# Rezoning Transportation Analysis

Petition Number: #2022-048

Date	Description
08-25-22	First Review (PDM)
09-22-22	Second Review (PDM)
10-27-22	Third Review (TM)
11-28-22	Fourth Review (TM)
01-25-23	Fifth Review (DR)

RZ-1

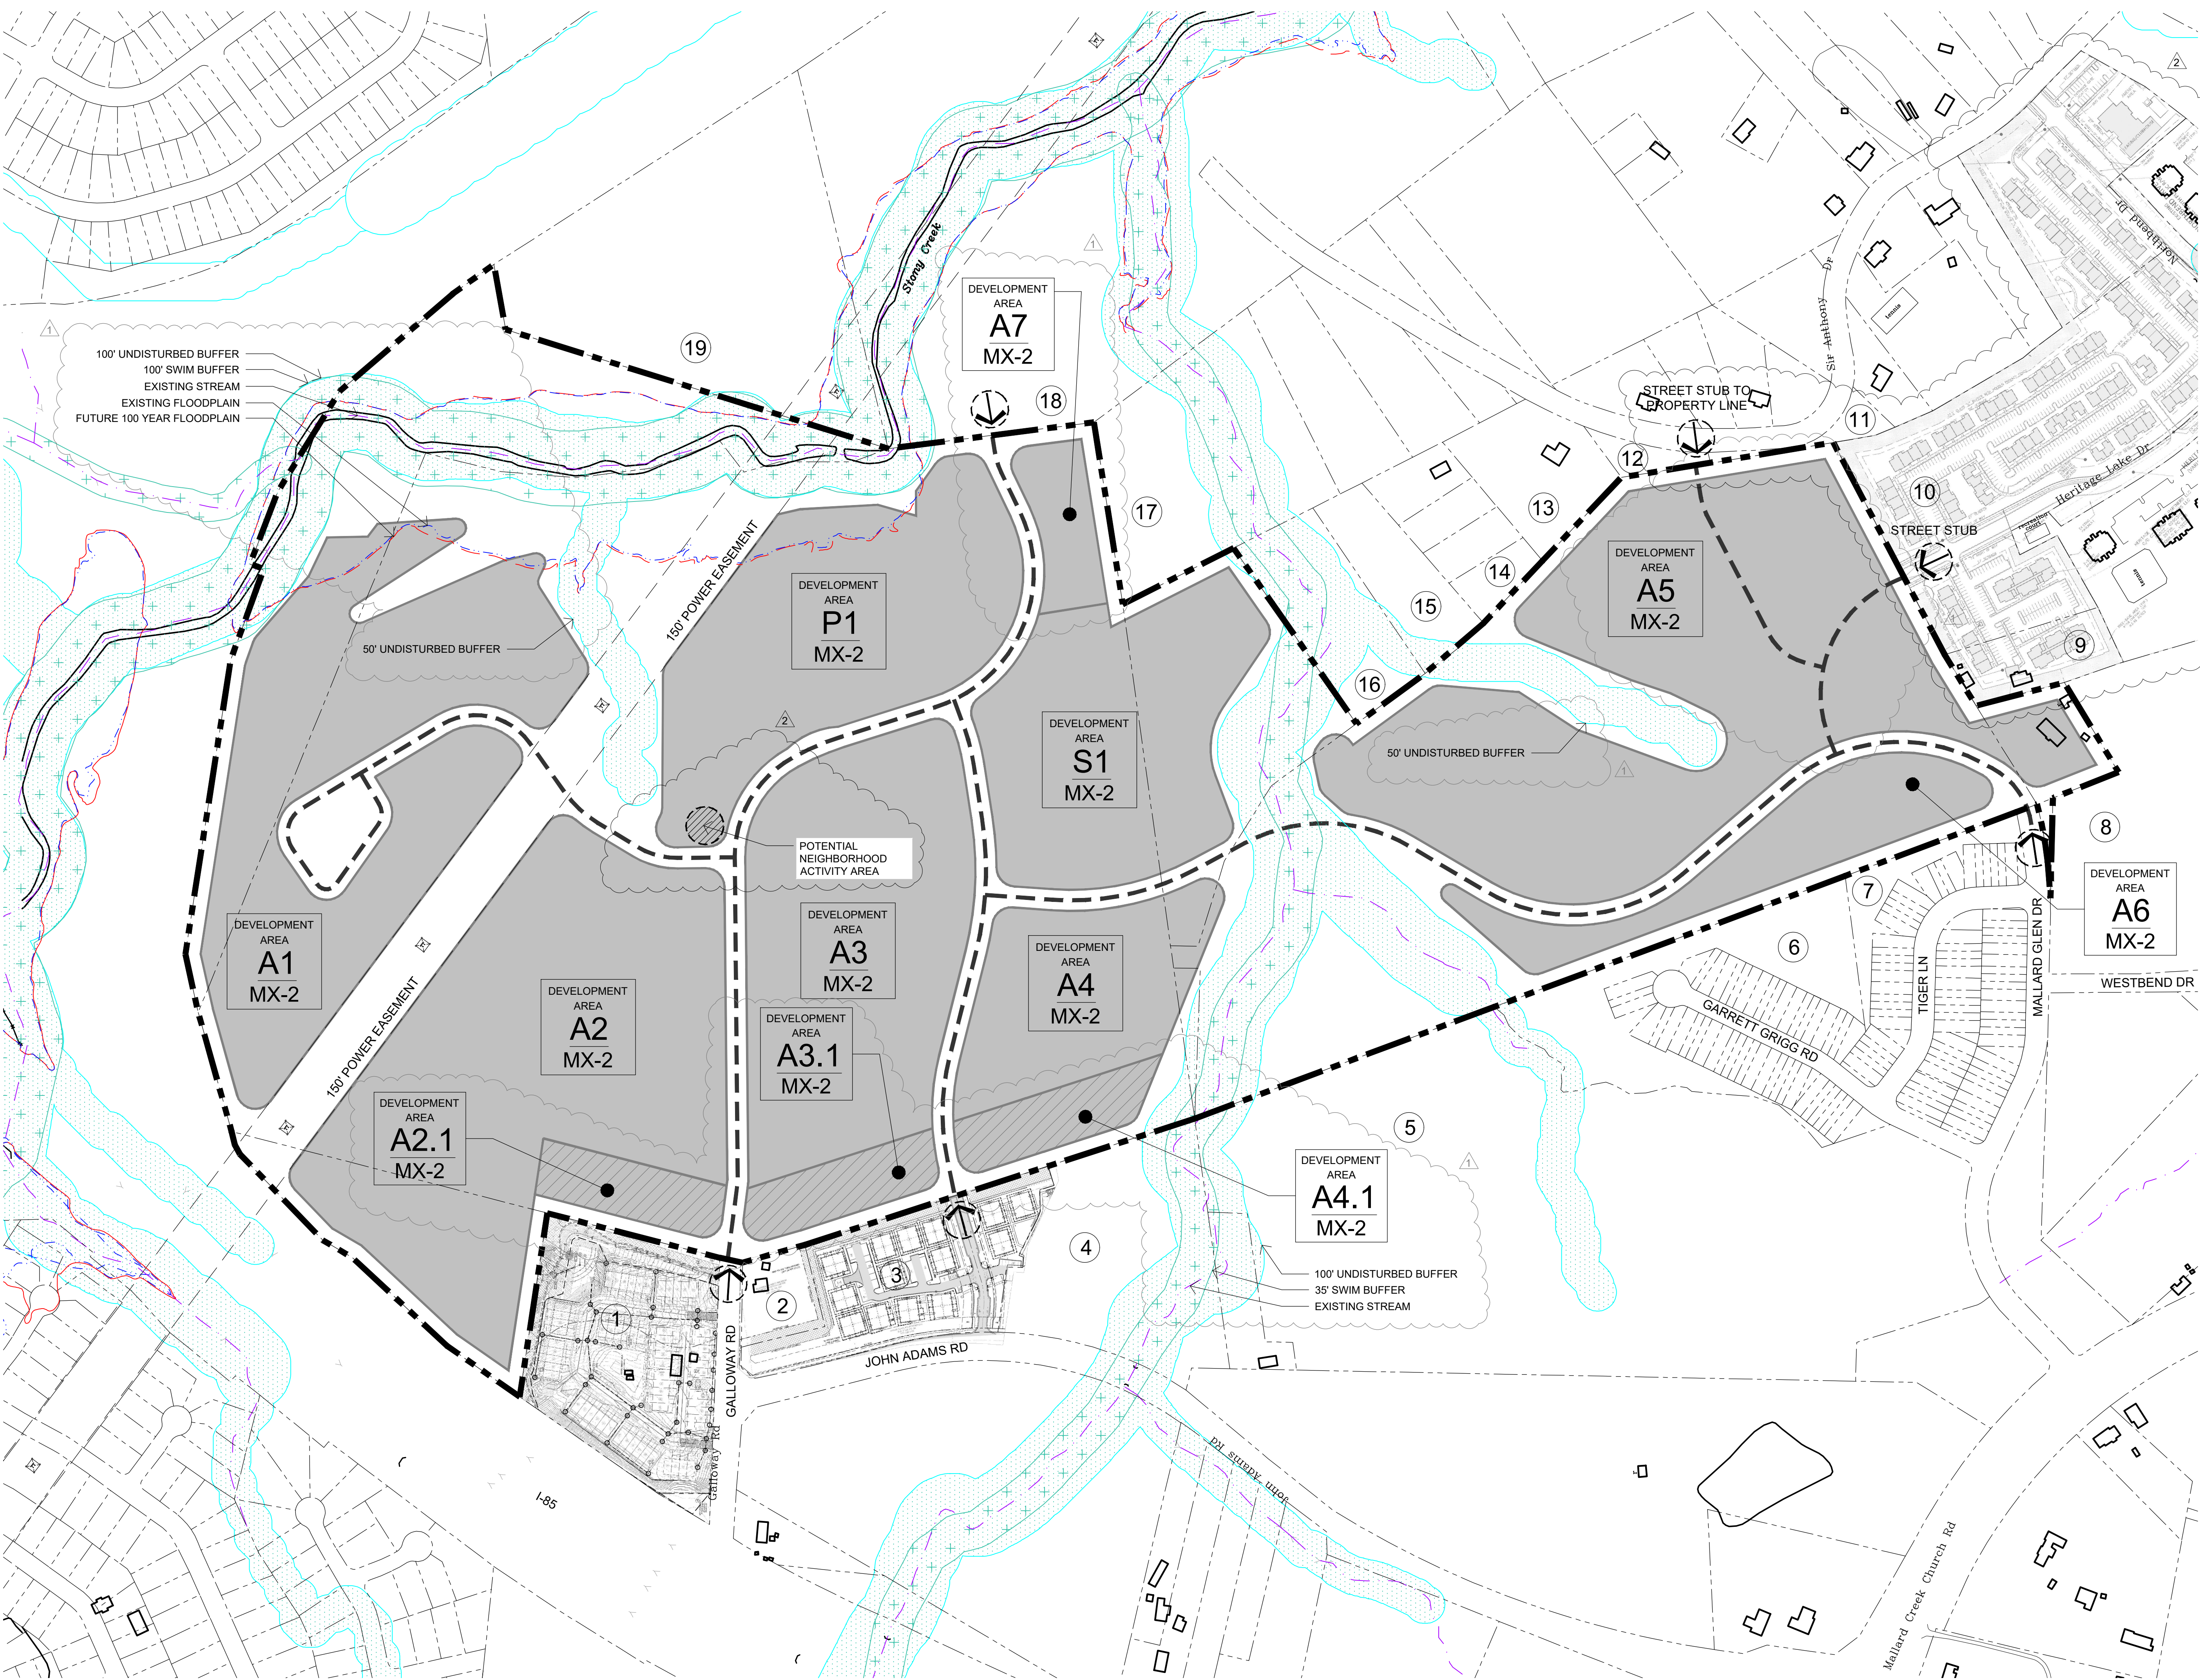
~~2. Outstanding Comment from 08-25-22: Revise site plan and conditional note(s) to commit to improving the existing Galloway Road stub to John Adams to the local collector street typical section per U-07.~~

RZ-2

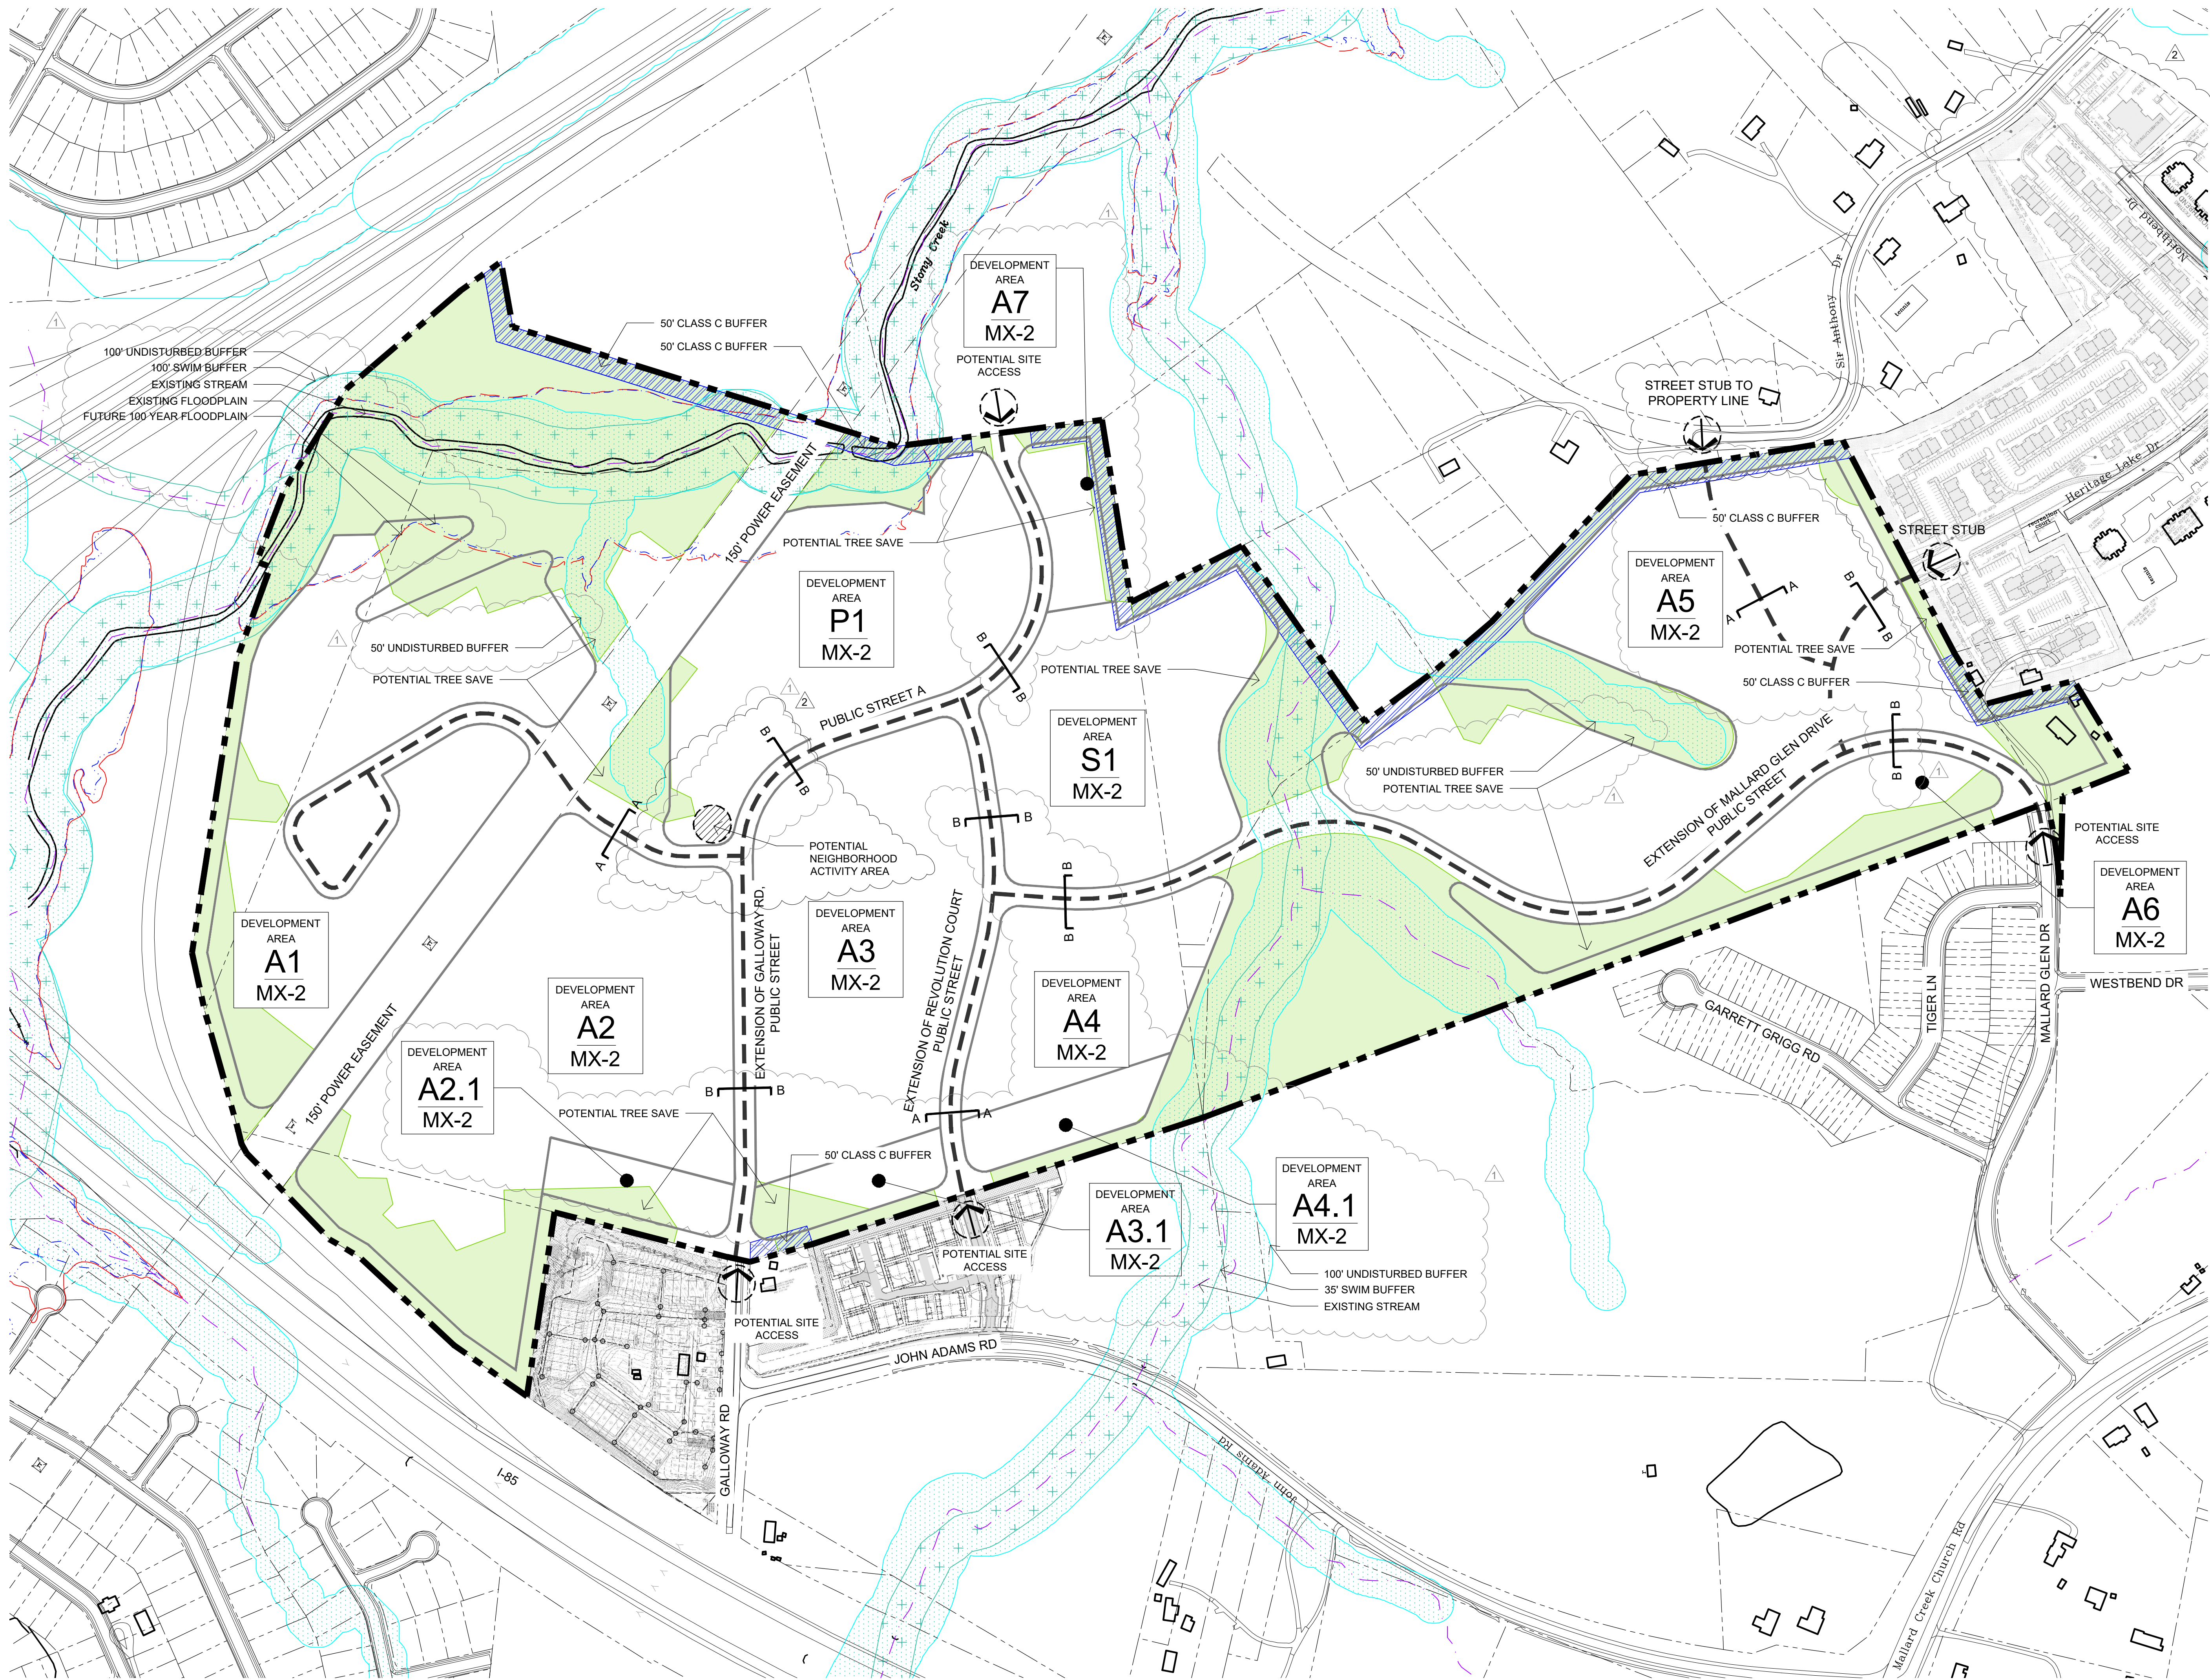
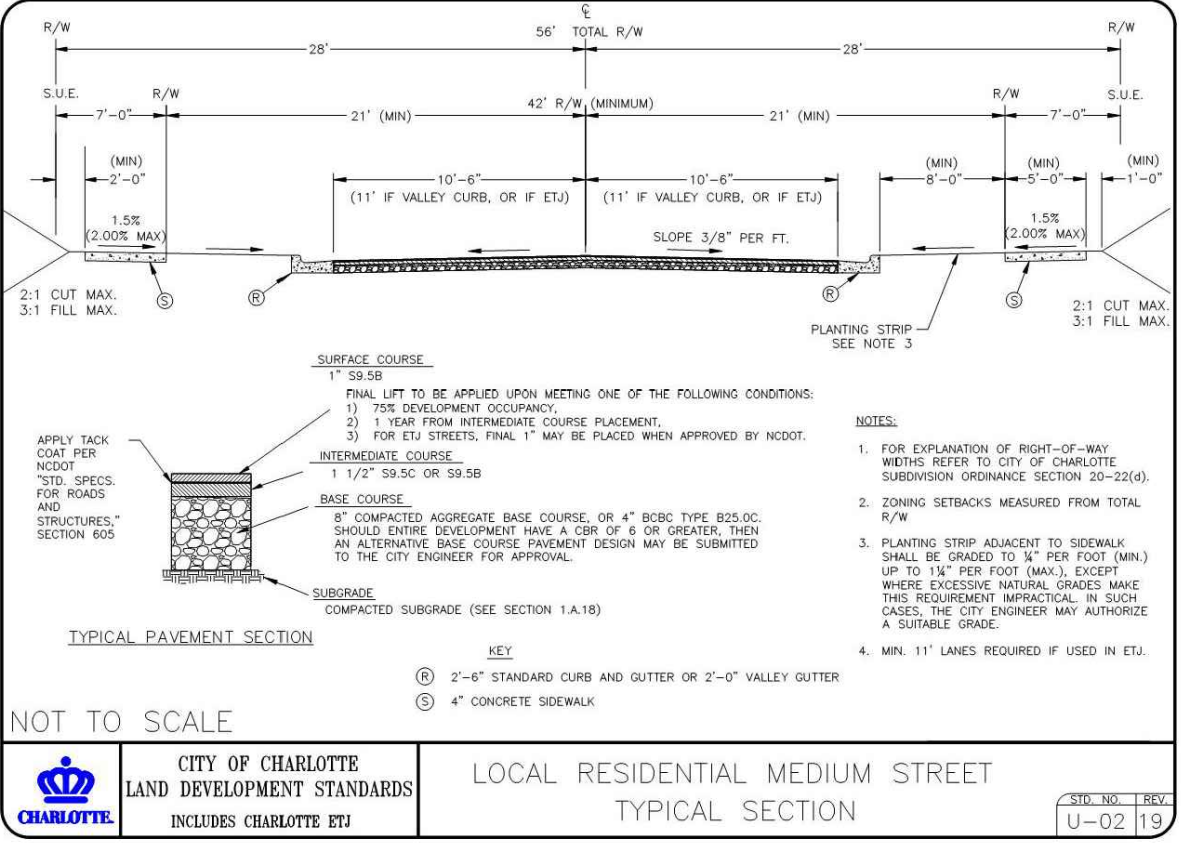
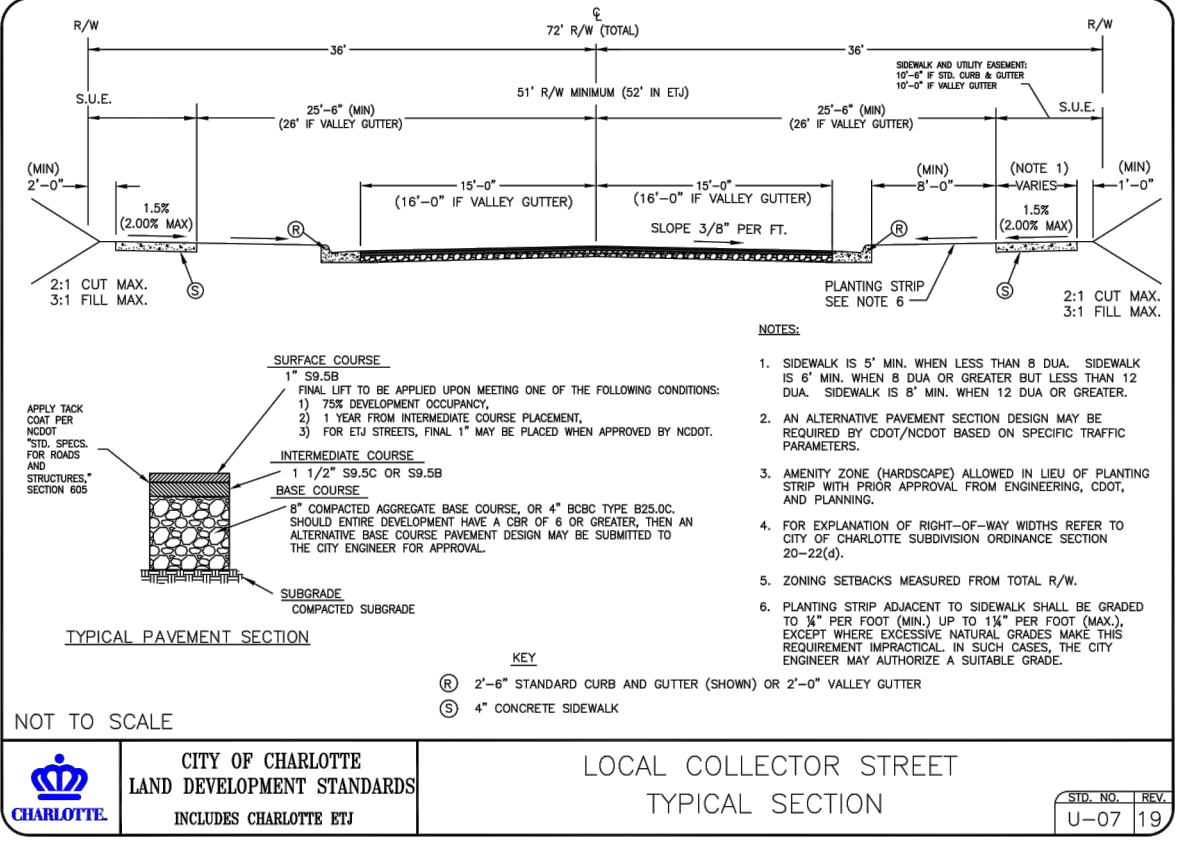
- ~~3. Revise site plan and conditional note(s) to commit to the proposed roadway network typical sections and proposed phasing outlined in the Traffic Impact Study. Provide typical sections per CLDSM for all proposed public and private streets. Provide 8 foot sidewalk and 8 foot planting strip on all public streets.~~
